1. INTRODUCTION

- 1.1 This response has been prepared by Paul Gibbs DipLA DipUD Director of David Jarvis Associates Limited (DJA), landscape architects and town planners.
- 1.2 It has been produced in response to comments received from Arun District Council (ADC) dated 13th February 2018.

2. LANDSCAPE BUFFER

Plan illustrating Proposed Landscape Strategy
produced by David Jarvis, 2016. NTS.

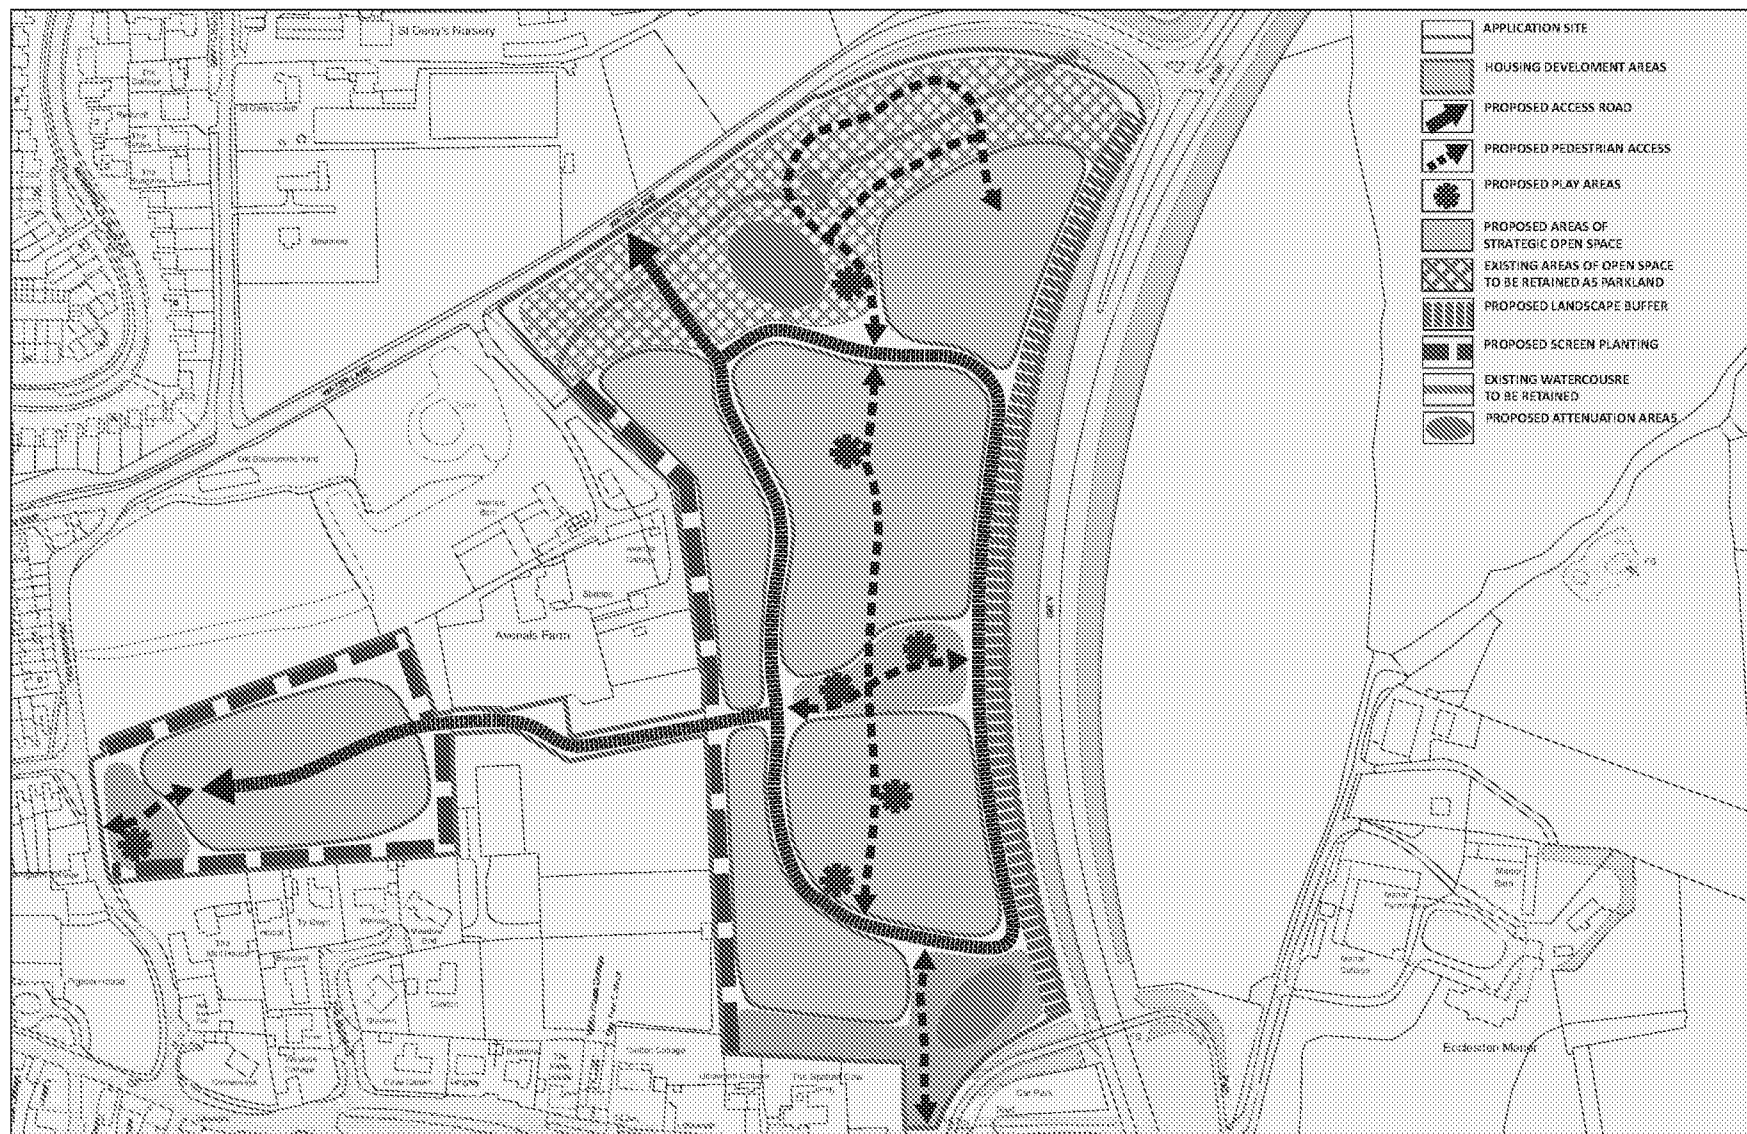
- 2.1 ADC considers that *“the provision of an additional 5.0 metre deep extension to the proposed landscape buffer along the eastern boundary of the site would mitigate the visual impact of the residential development and ensure that the current outline planning application accords with the NPPF, Policy GEN7 of the Local Plan, Policy HD5 (Built Form) of the Neighbourhood Plan and Policy LAN DM1 of the modified eALP.”*

- 2.3 The landscape strategy found at page 78 of the submitted DAS dated May 2017, shows a landscape buffer along the entire length of the eastern boundary.

- 2.10 From the photomontages and observations on site it is concluded that the thickening of the buffer by 5m along its entirety would not provide any additional screening of consequence. The buffer is sufficiently thick to provide the screening required in the LVIA and to address the Inspector's concerns.

- 2.12 To assist the development of the buffer and provide a more immediate effect a condition could be put in place that requires the buffer to be planted using a mixture of plant sizes. This could include some individual trees amongst the woodland matrix planting incorporating advanced nursery stock and a small percentage of semi mature trees. This would reduce significantly the time required to create a substantial planted screen.
